**Residential Development, Cornelscourt, Dublin 18**

**Preliminary Design Stage Quality Audit**

**Cornel Living Ltd.**

**Report Ref:** p180208-Rep-009

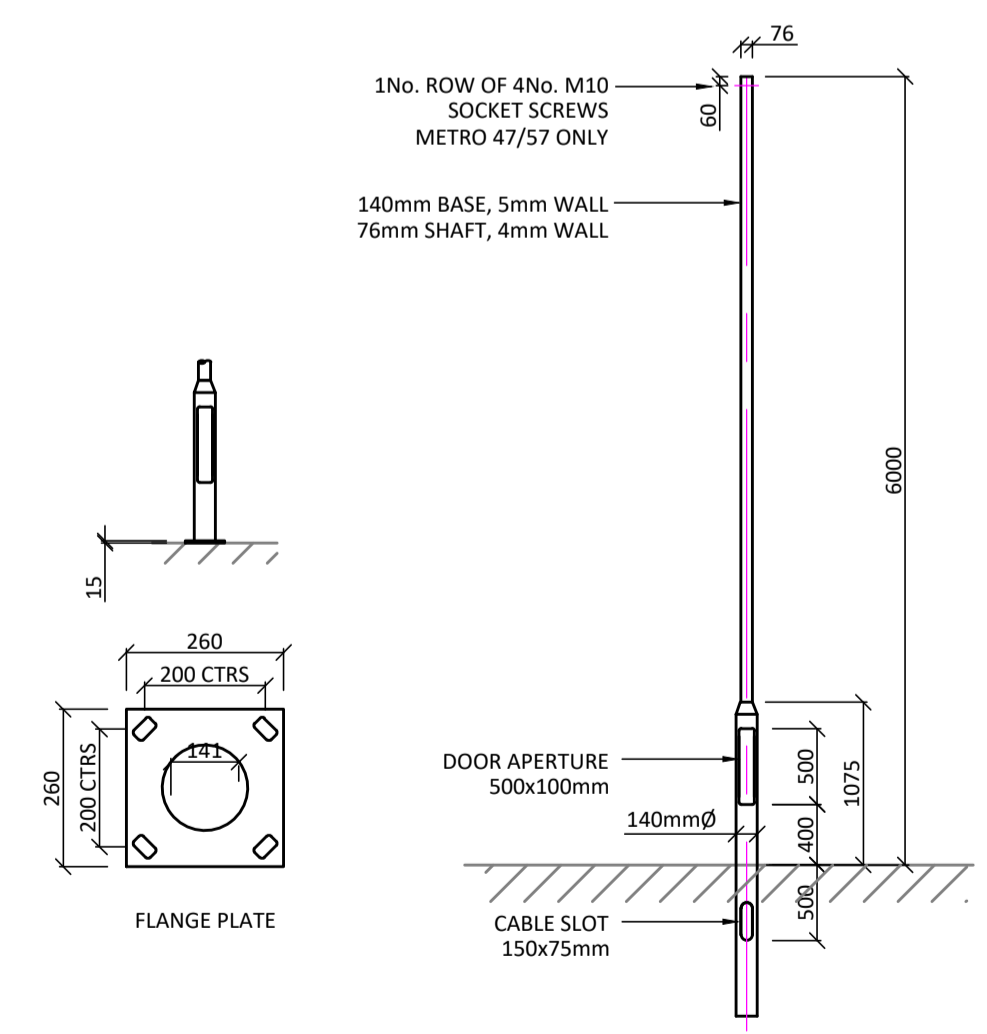
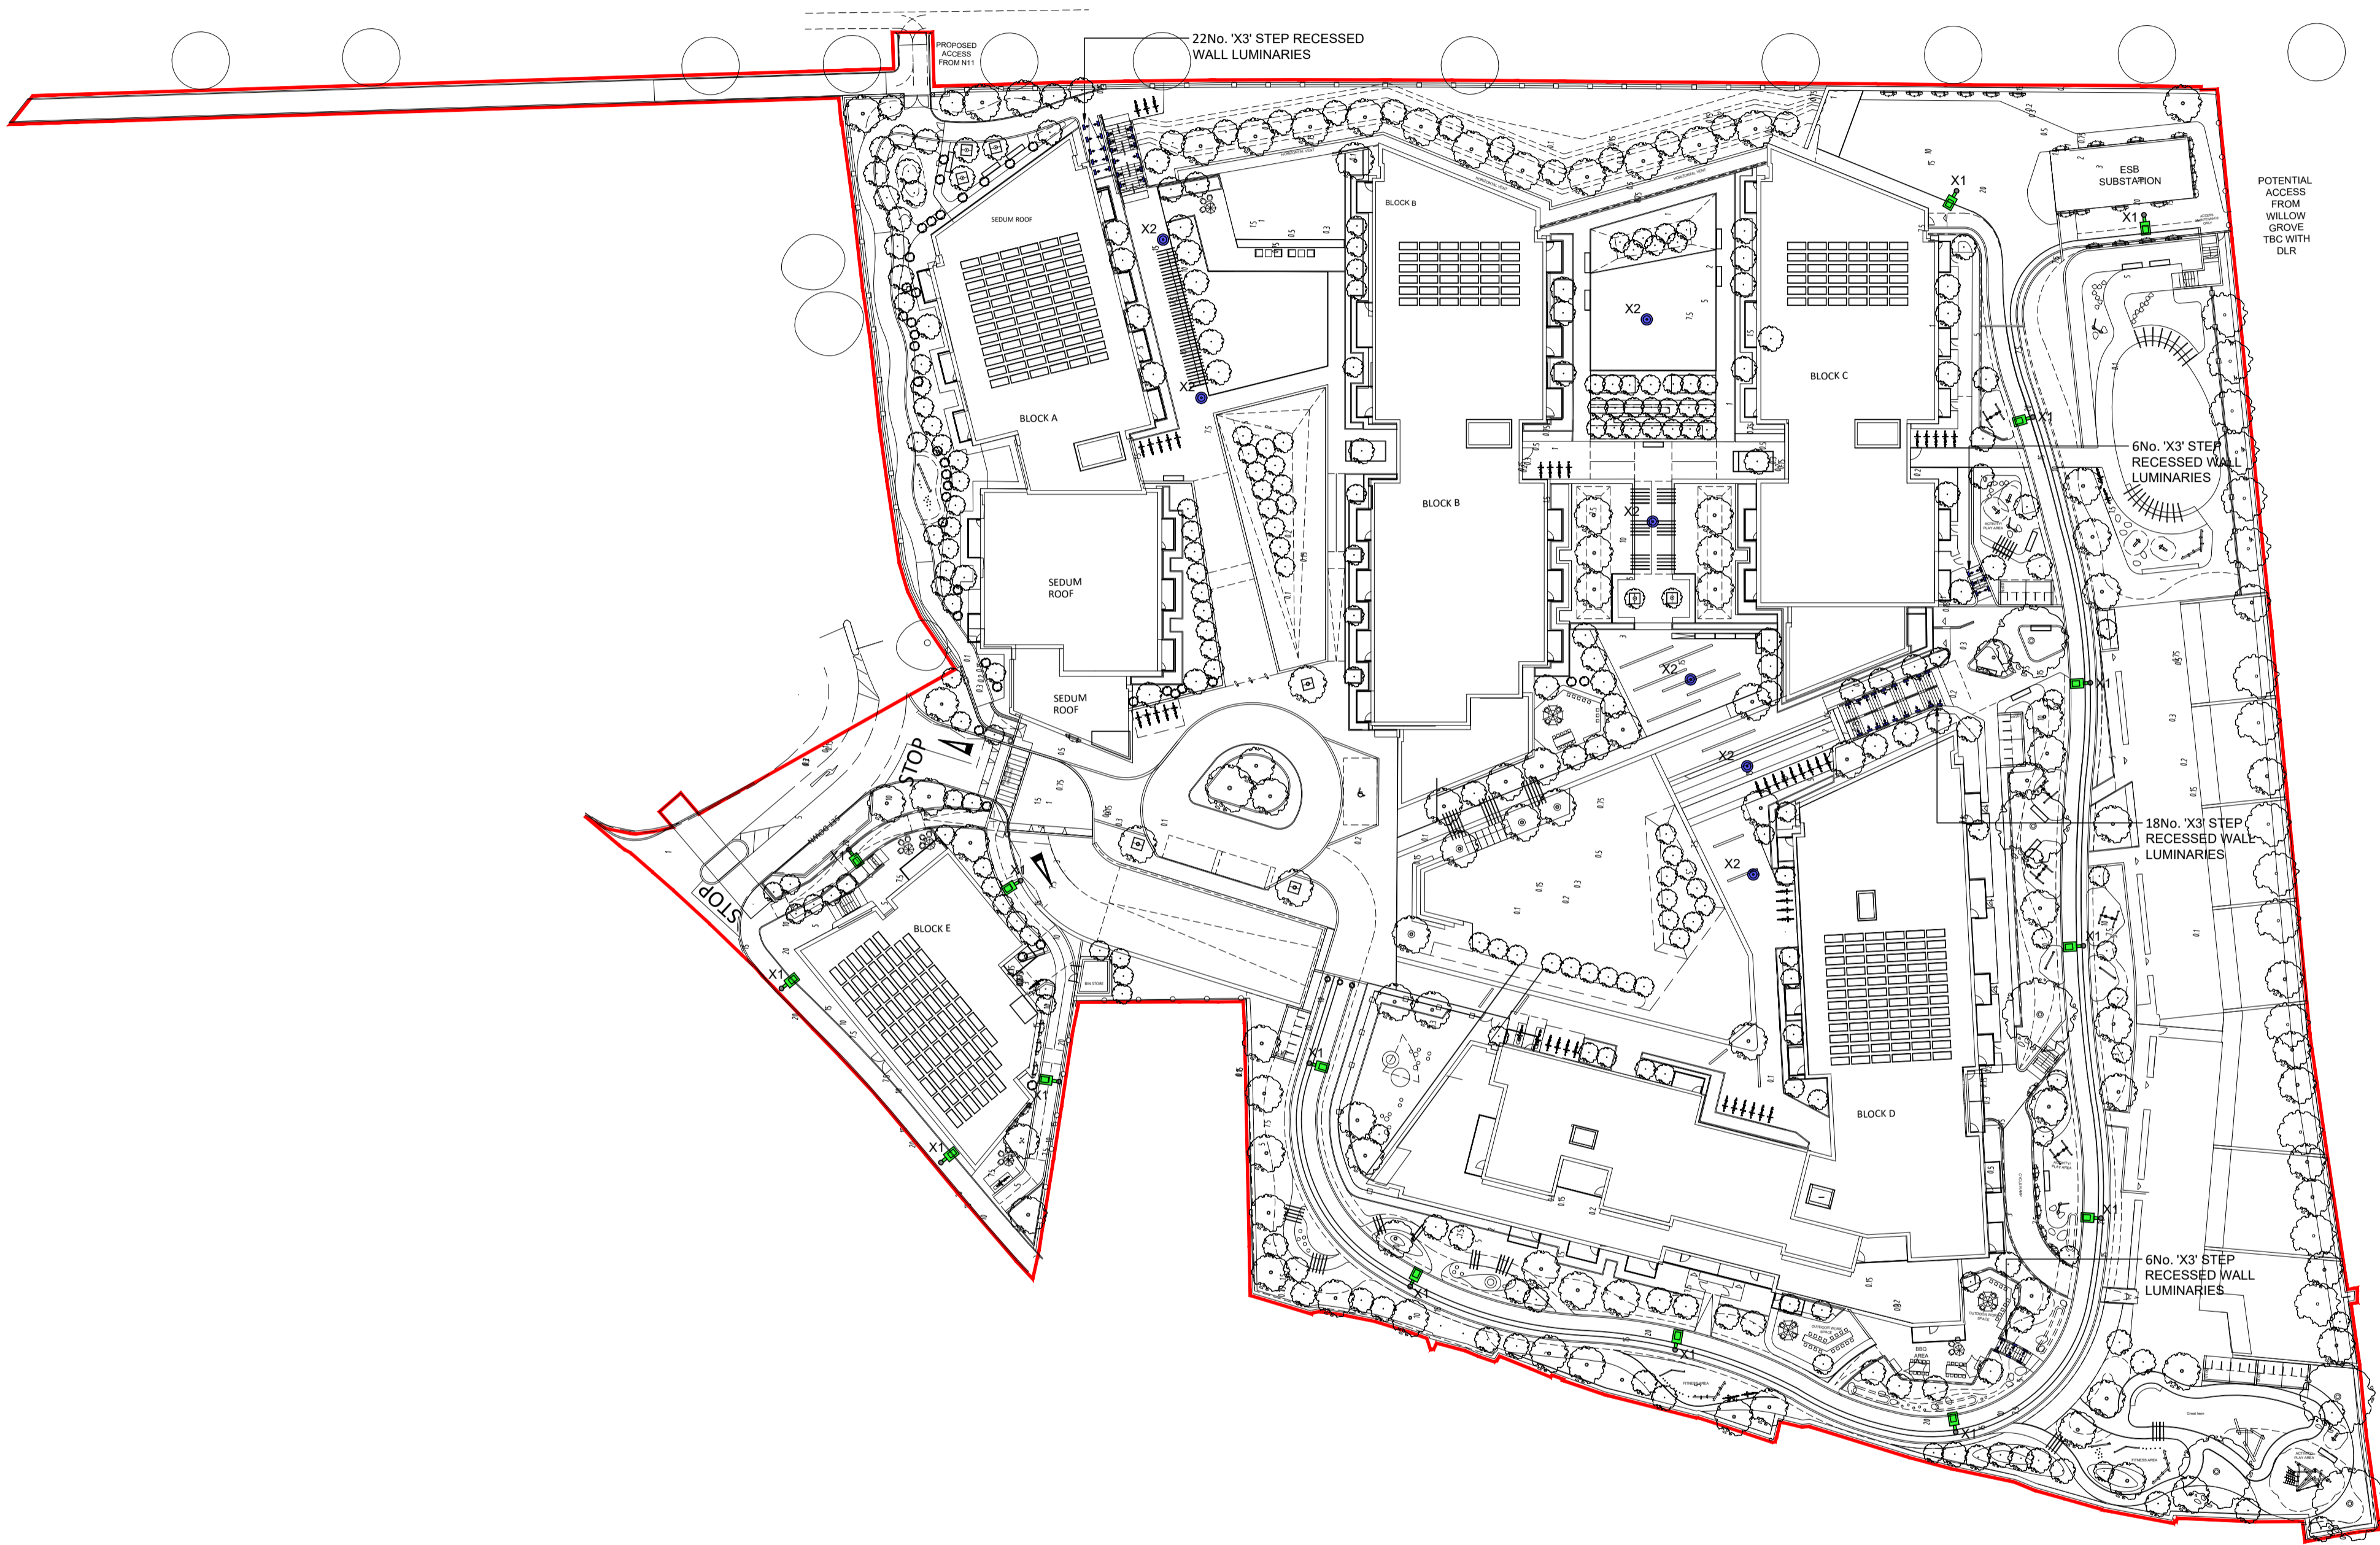
The drawings provided for the purpose of this audit do not detail the provision of street lighting along the pedestrian routes within the subject site. In the absence of appropriate street lighting, safety issues such as trip hazards could arise for pedestrians whilst personal security issues could prove a significant concern for pedestrians and cyclists.

During the detailed design stage, appropriate levels of internal (and external along any new pedestrian / cycle connections if necessary) lighting should be provided across all pedestrian, cycle and vehicle routes. The location of the street lighting columns should also be carefully considered to ensure that they do not impact access levels or present a hazard.
